Application No: BE/52/20/HH
Site Address: 3 Berghestede Road Bersted PO22 9QR
Description of works: Loft conversion and ground floor side extension.

Thank you for your internet representation made on 7th August 2020 which has been recorded as an objection with the comments as follows:

Proposed East Elevation

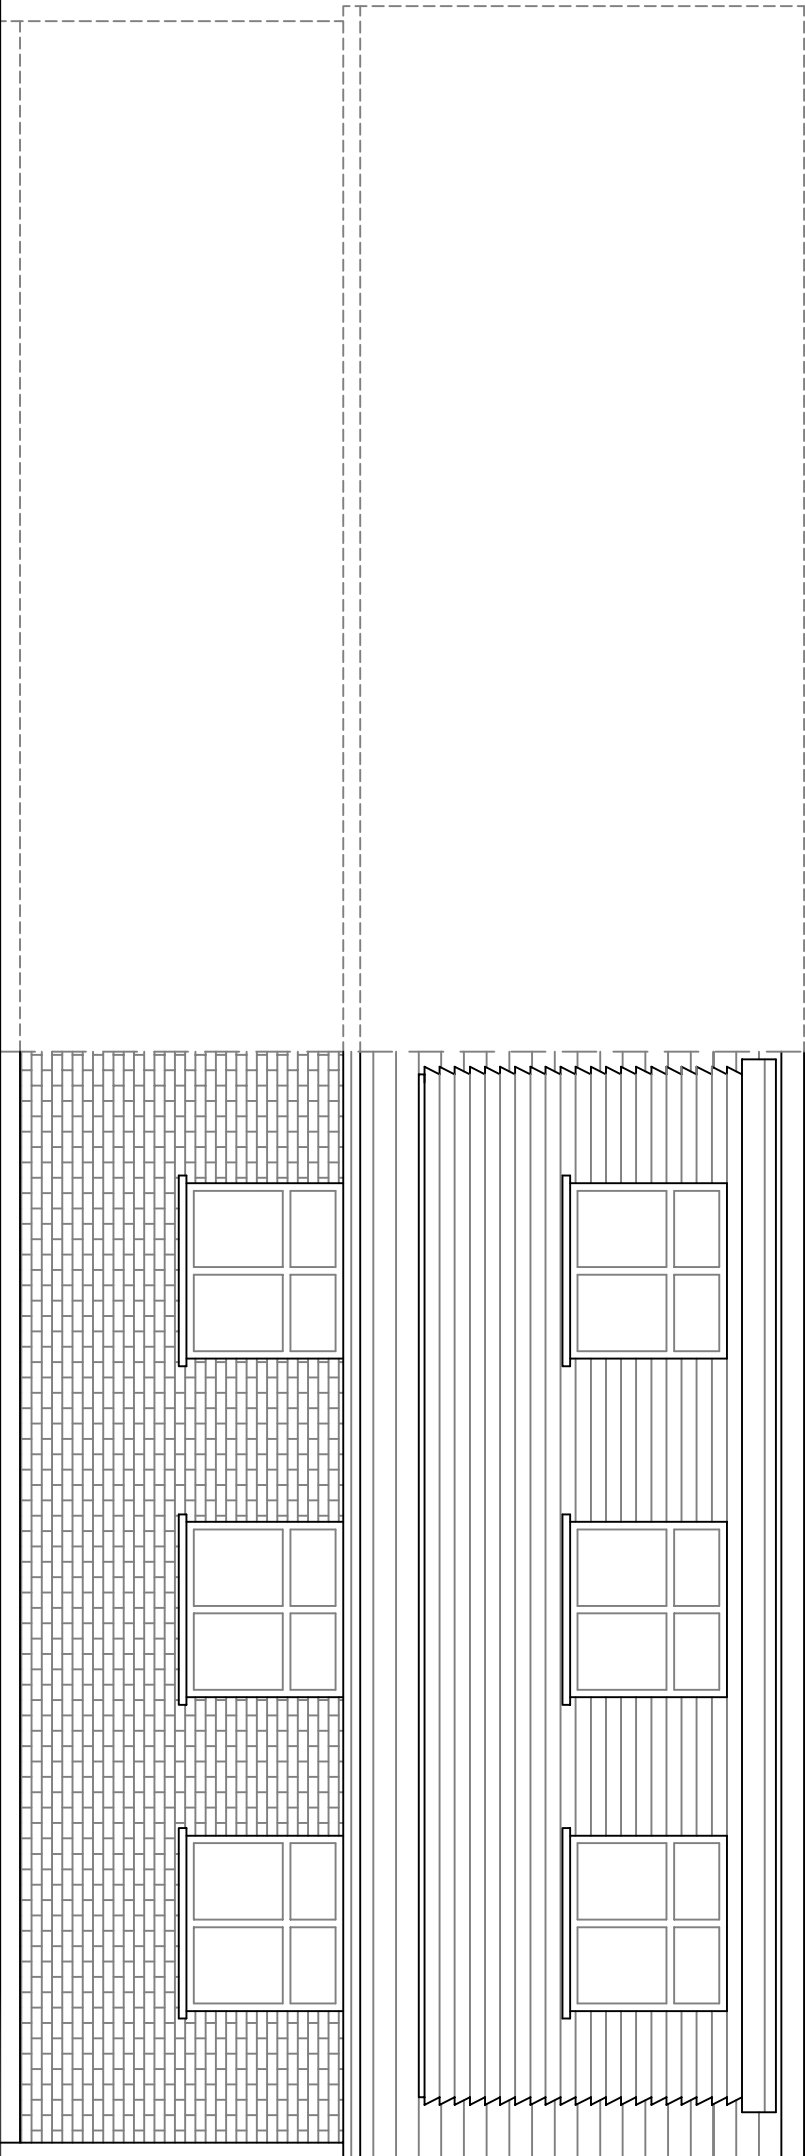
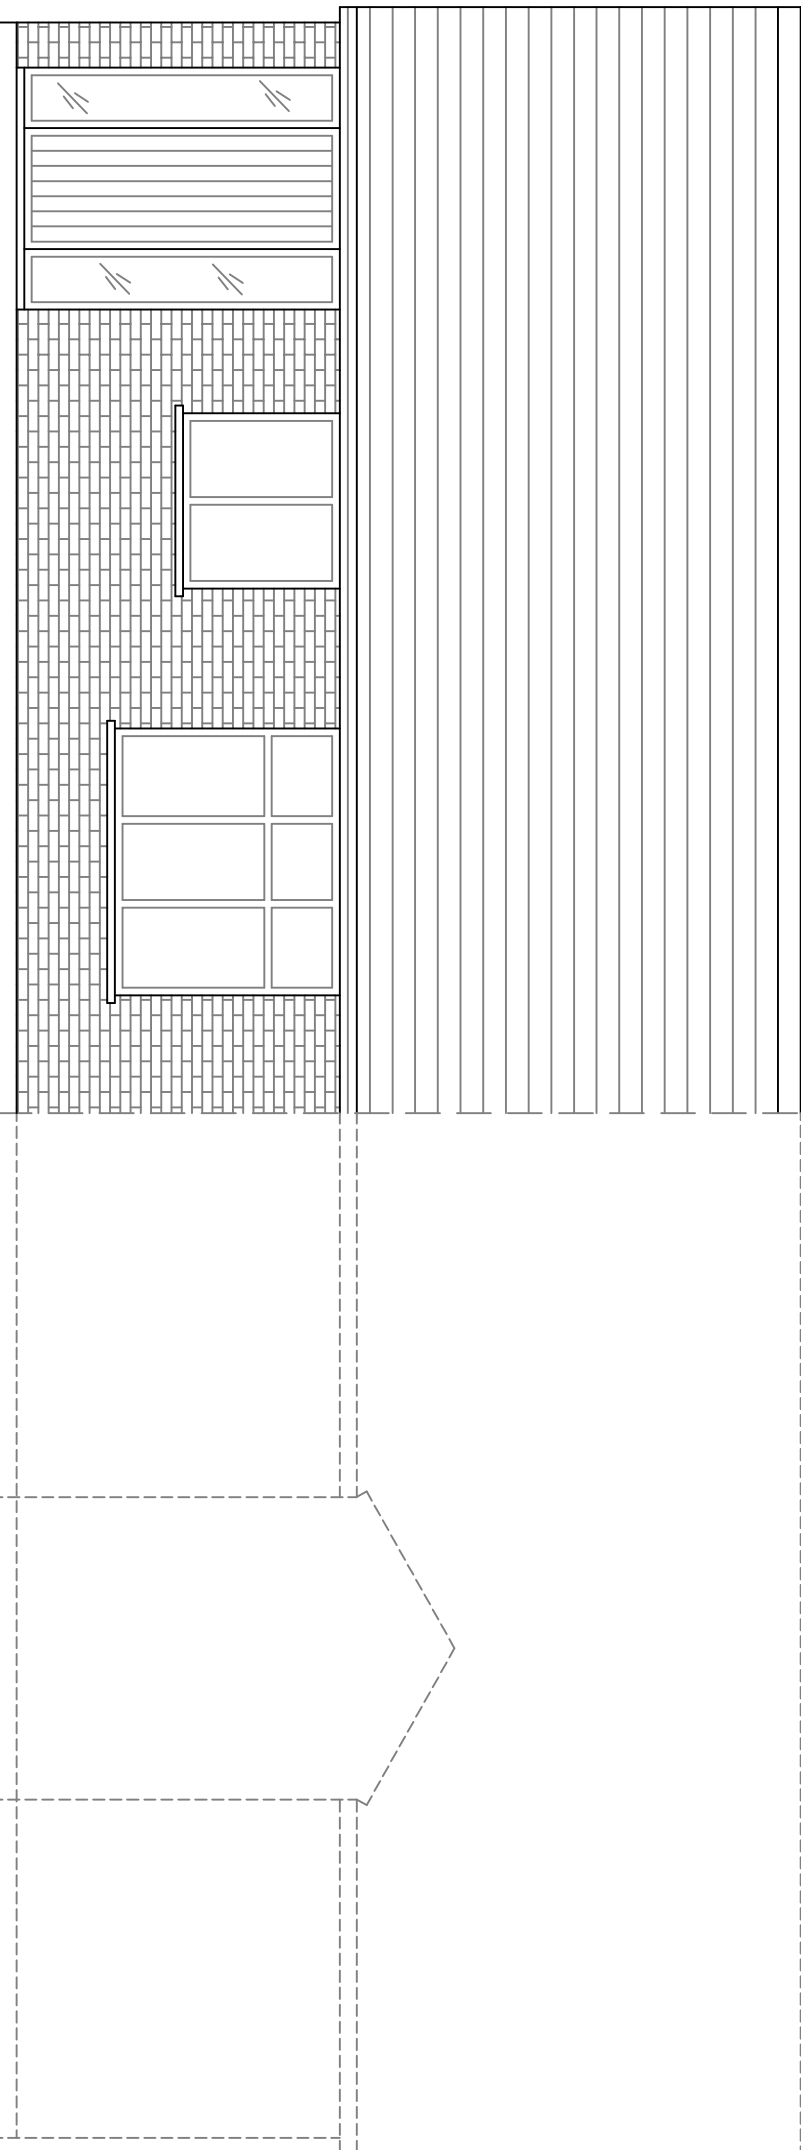
Whilst I do not object to the conversion and the extension to the side of the property. I do object to the dormer windows that will overlook my property and have an impact on my privacy. I do not see why the dormer windows could not be sited on the front elevation {west}, where no one will be overlooked as there is a road with a greensward opposite. If there is a justifiable reason for the windows being at the rear of the property, Velux windows should be used.
